Kirklees Council Planning & Development Service
PO Box B93, Civic Centre 3, Off Market Street, Huddersfield, HD1 2JR

Your reference: 2021/94239 and 121, Slaithwaite Road, Meltham, Holmfirth, HD9 5PW.

{3D}

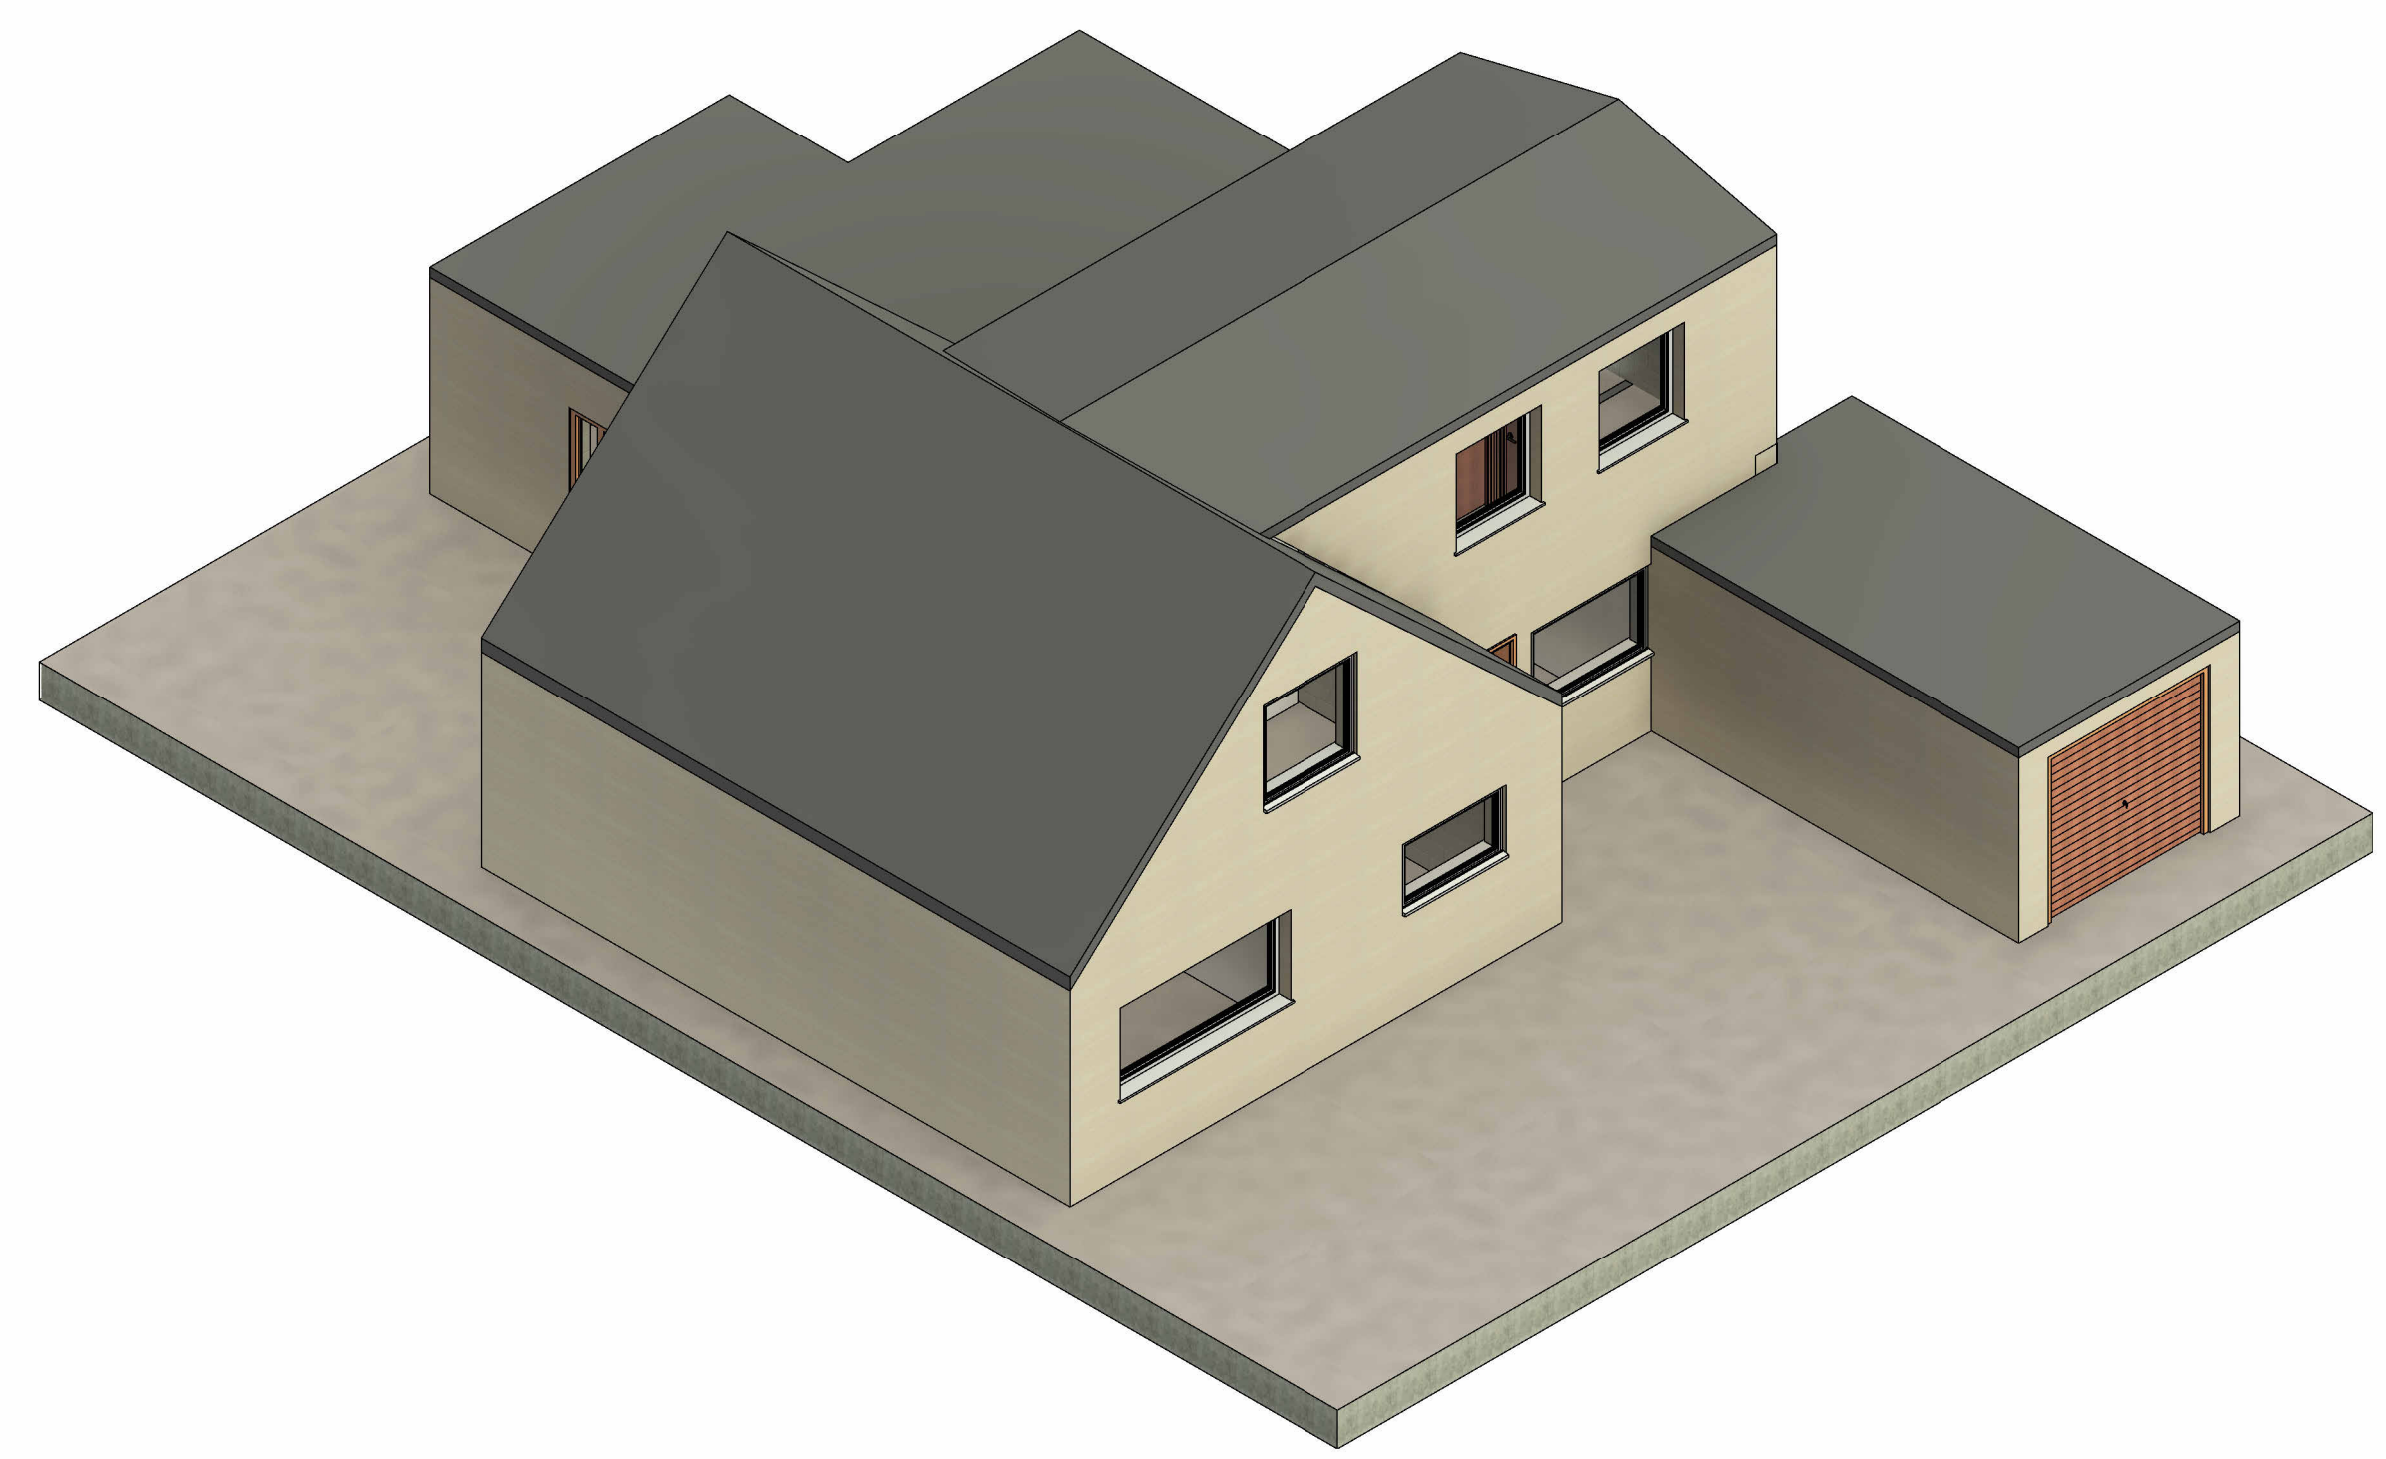
- 2) I would welcome a 3D view of the proposed elevations of the building. I note that one was provided with the original planning application 2021/93100.
